Ms Poonam Chauhan
Development Manager
UNIT 4 161
REDFERN STREET
REDFERN NSW 2016

**Doran Drive Plaza Precinct (SSD-15882721)
Response to Submissions Report**

Attachment A

Dwg No.
DA-730-101

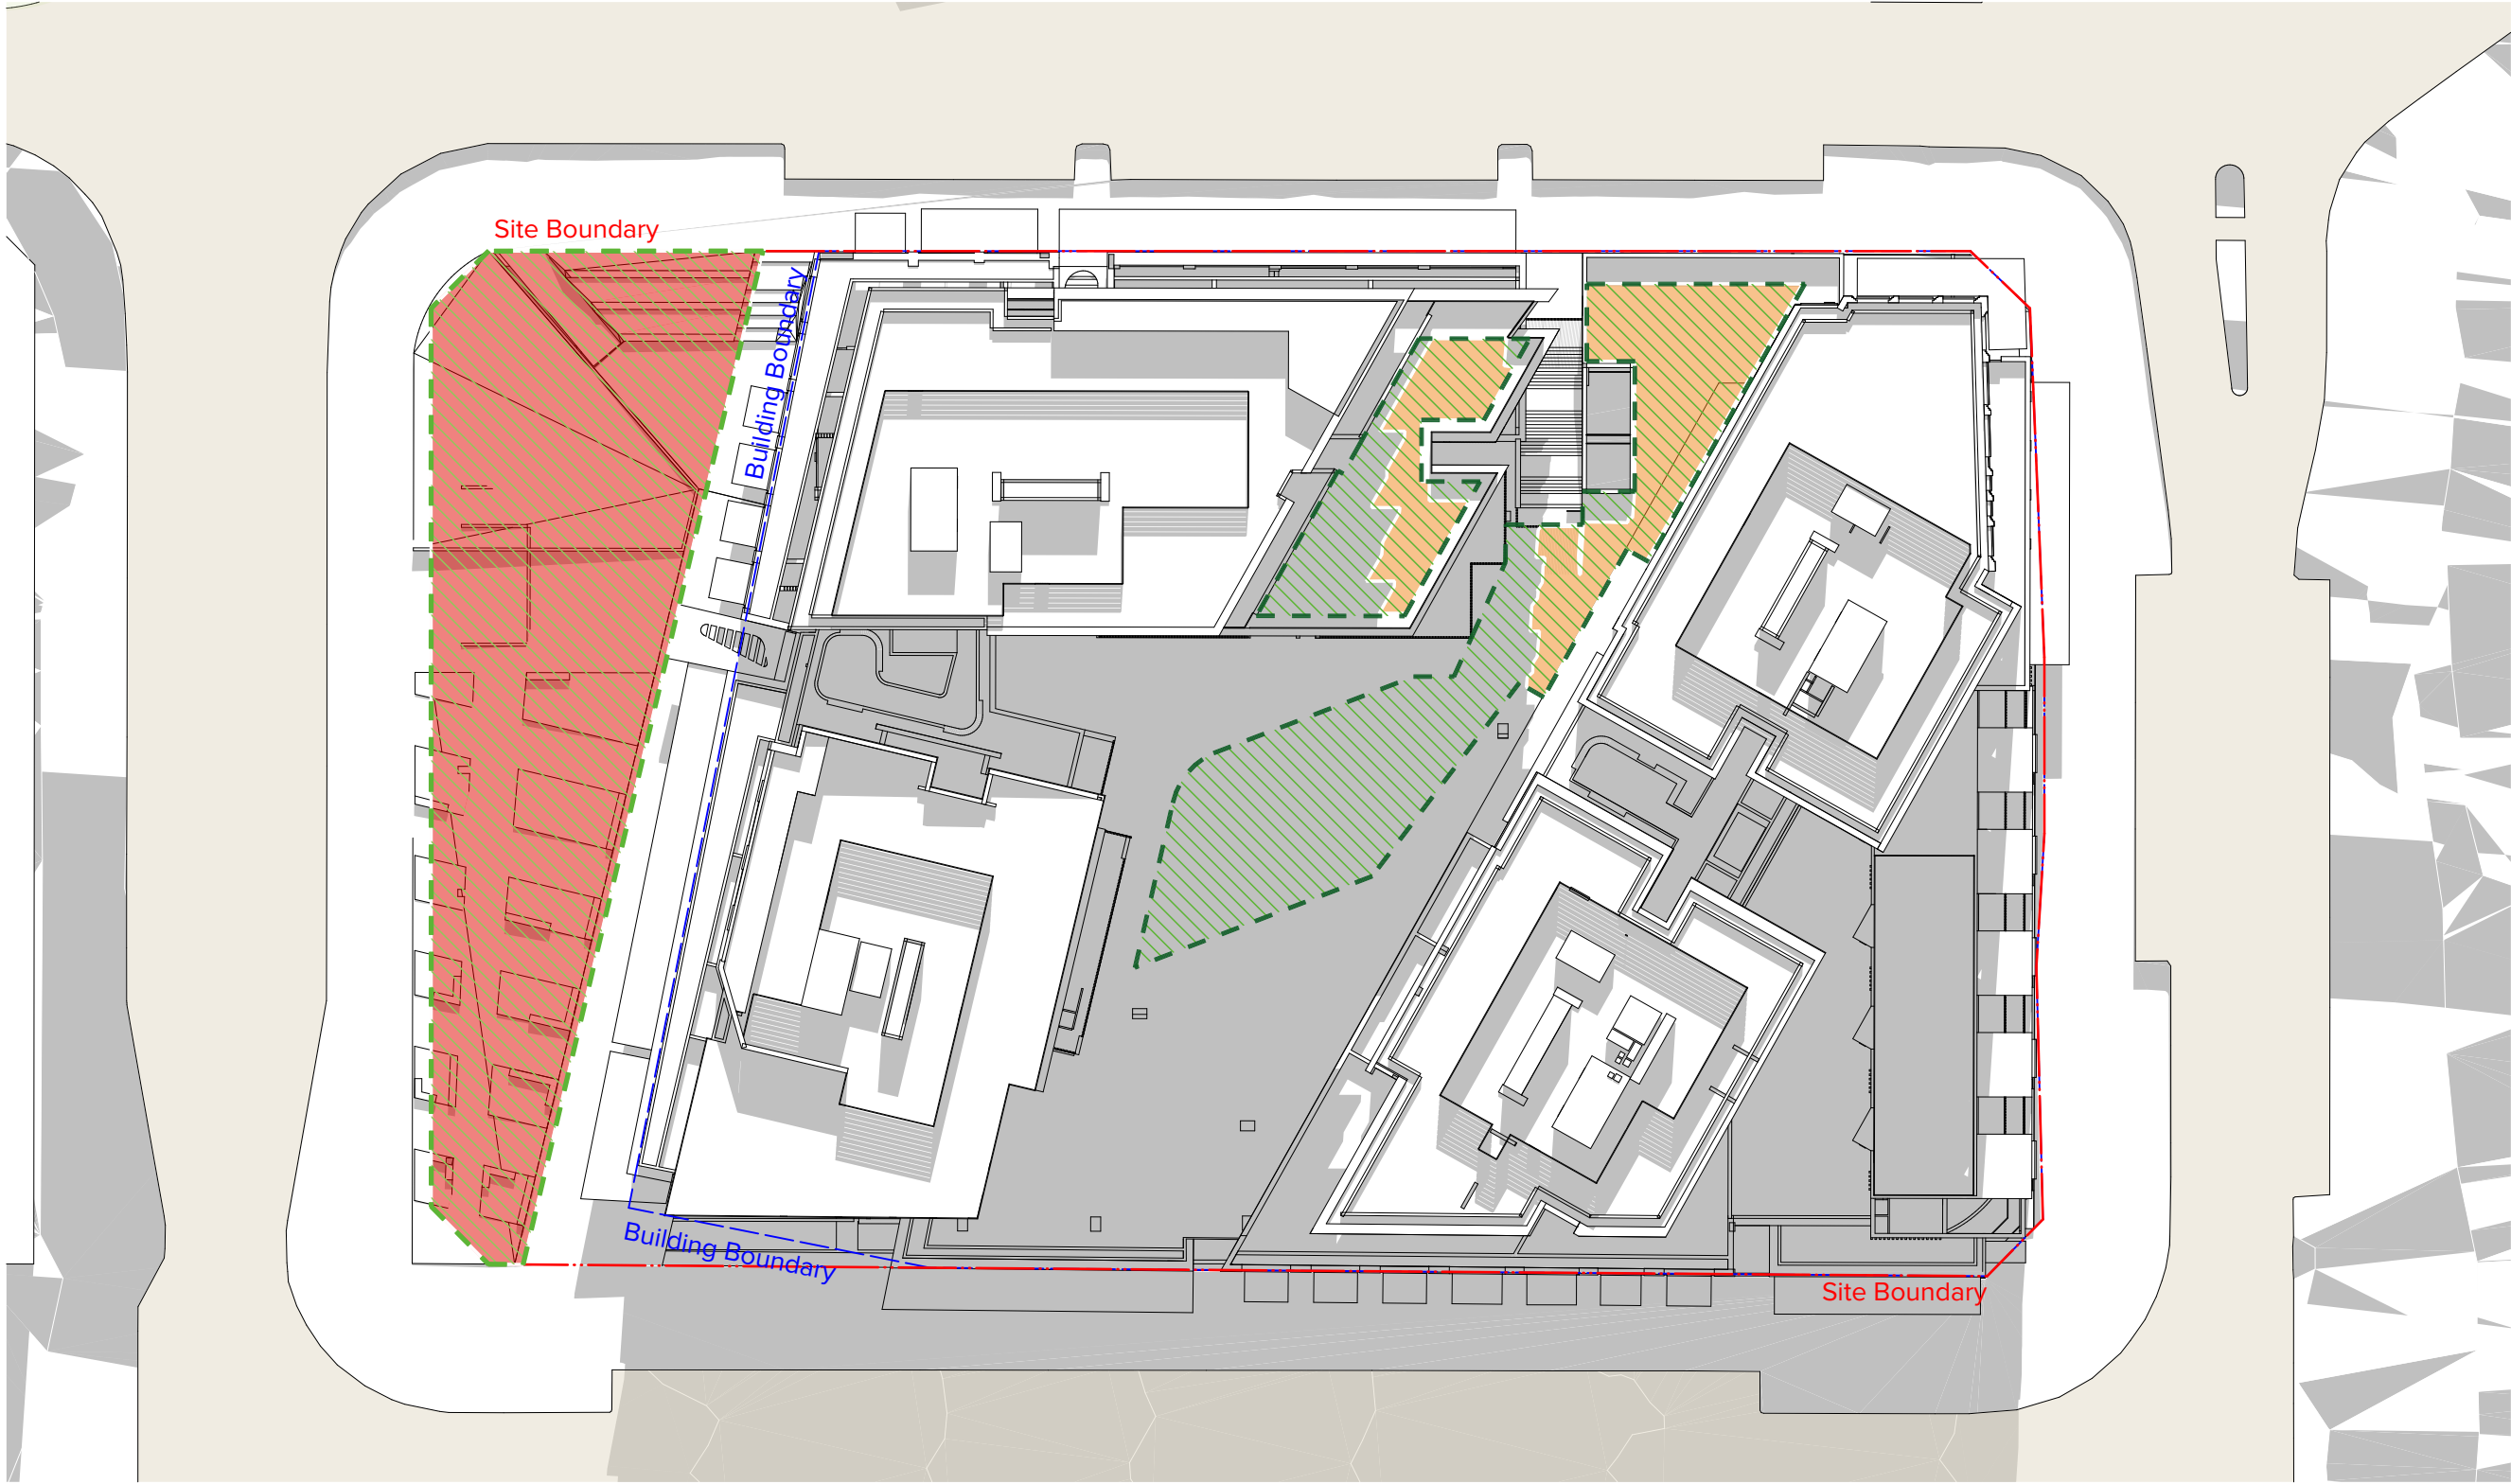
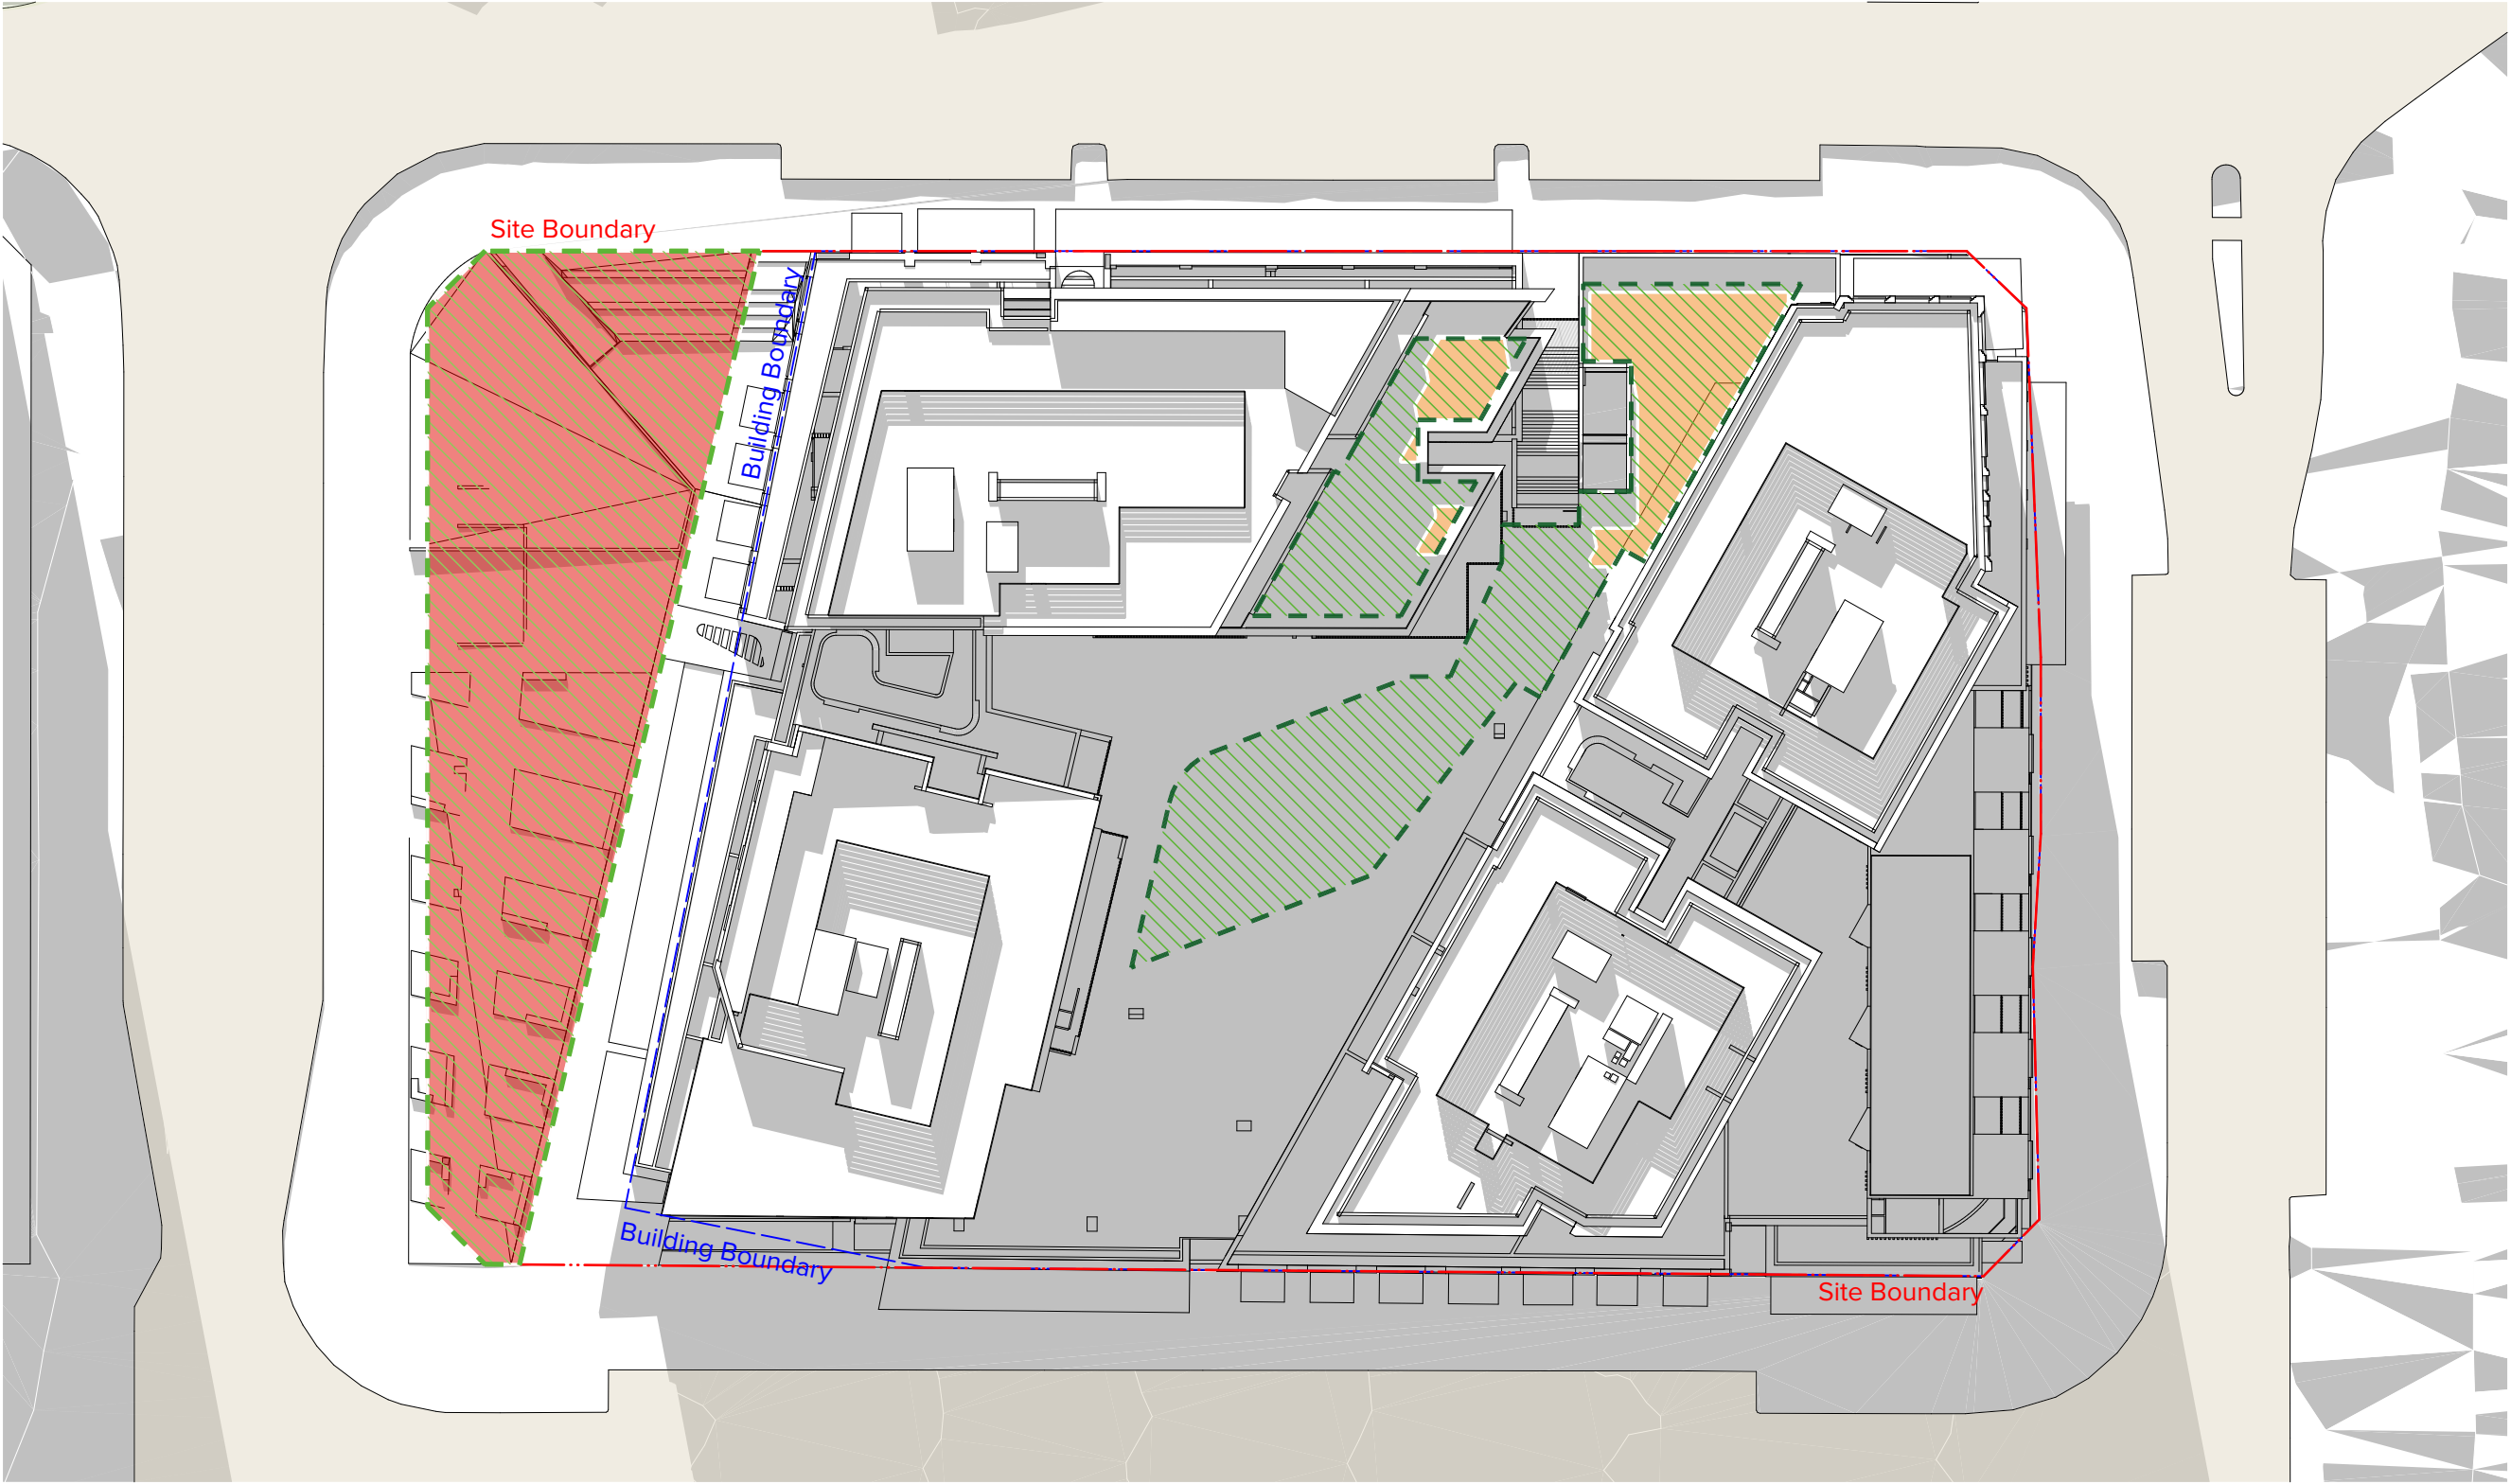
- a) Review and amend the proposal to meet the Apartment Design Guide (ADG) requirements for:
 - minimum solar access to apartments
 - communal open space, in terms of quantity identified as usable area and minimum solar access
